OWL MARKETPLACE FILING NO. 1

A REPLAT OF LOTS 14 & 15, FALCON RANCHETTES, LOCATED IN THE NORTH HALF OF THE SOUTHEAST QUARTER OF SECTION 1, TOWNSHIP 13 SOUTH, RANGE 65 WEST OF THE SIXTH PRINCIPAL MERIDIAN, COUNTY OF EL PASO, STATE OF COLORADO

PCD FILE VR2321

Sheet 1 of 3

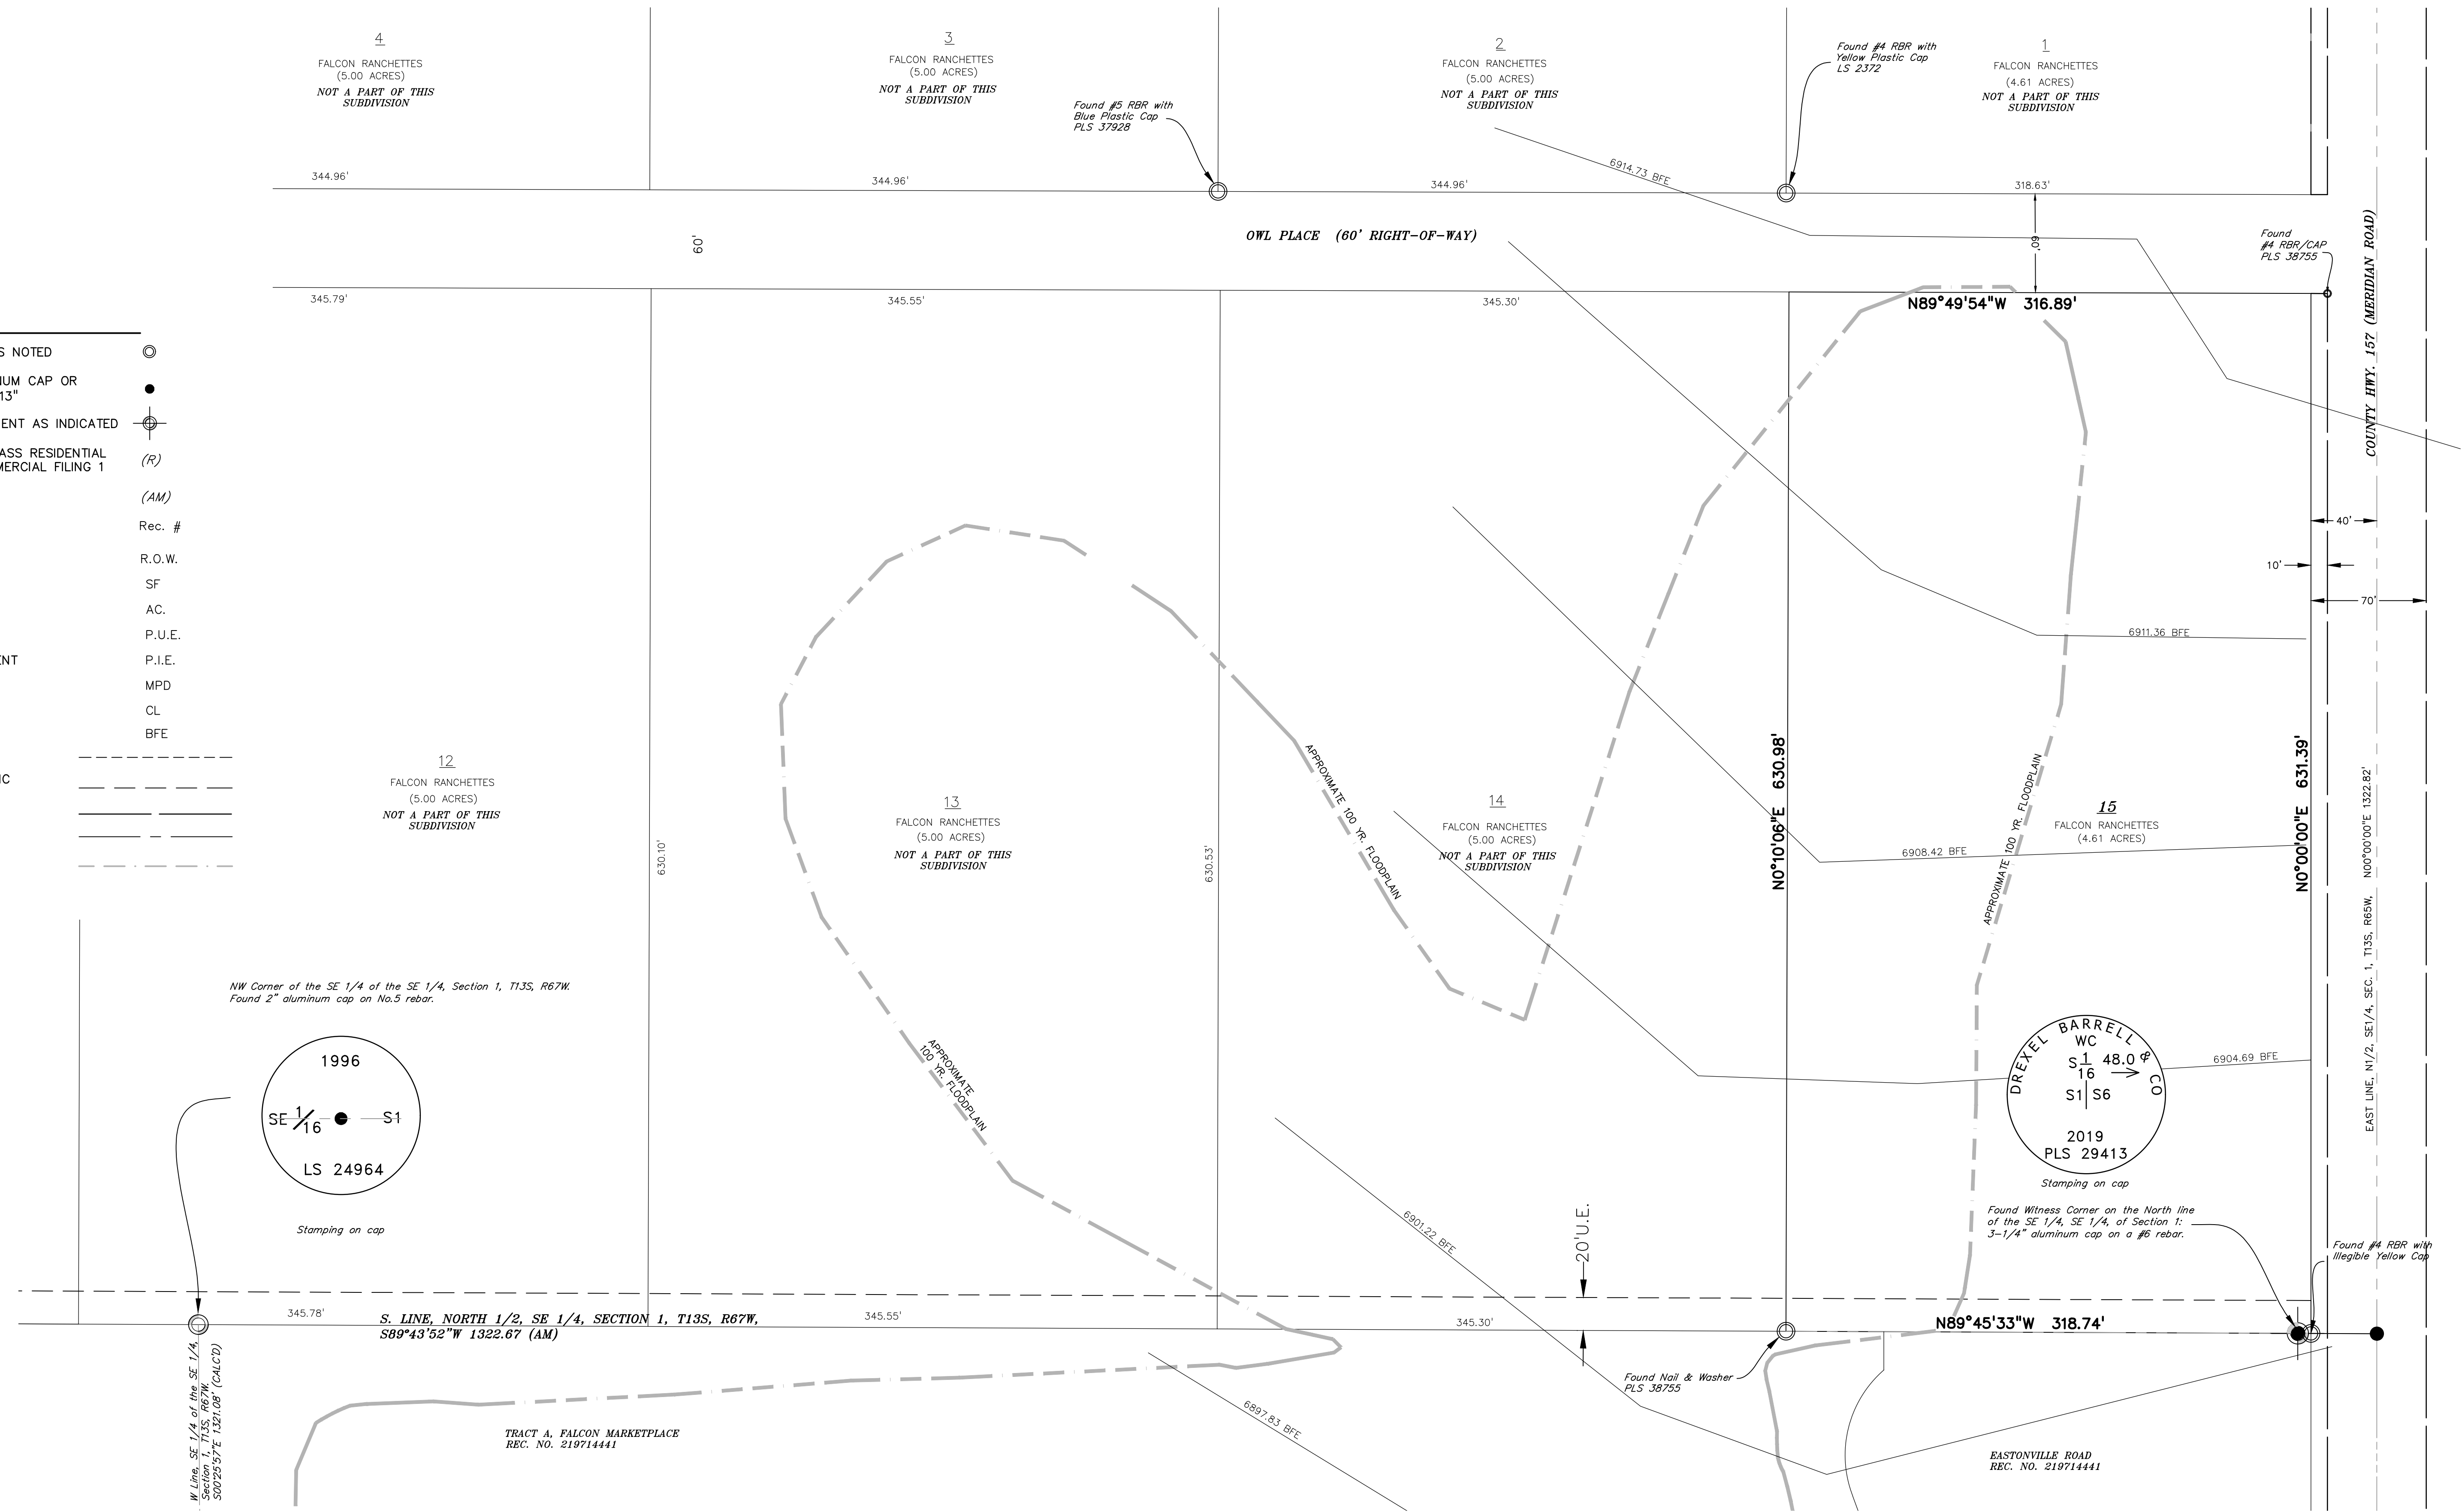
Please also include lot 14 as it is also part of the plat.

Add the following note:

Dedication statements for streets, parks, trails, open space, schools, or other uses and dedication of public streets, alleys and easements to the County. All rights-of-way being dedicated to El Paso County shall be clearly labeled with the following statement: "Dedicated to El Paso County for right-of-way purposes by this plat".

Add the following plat notes from the previous review comment:

- All property owners are responsible for maintaining proper storm water drainage in and through their property. Public drainage easements as specifically noted on the plat shall be maintained by the individual lot owners unless otherwise indicated. Structures, fences, materials or landscaping that could impede the flow of runoff shall not be placed in drainage easements.
- No driveway shall be established unless an access permit has been granted by El Paso County.
- There shall be no direct lot access to Meridian Road

Add the following note:

Gas and electric service for this subdivision is provided by _____ (Provider name(s)) subject to the District's (Providers) rules, regulations and specifications. (Combined note, which can be broken into separate notes for gas or electric in the case of different providers)

Water finding is required for Lot 5 with this subdivision application.
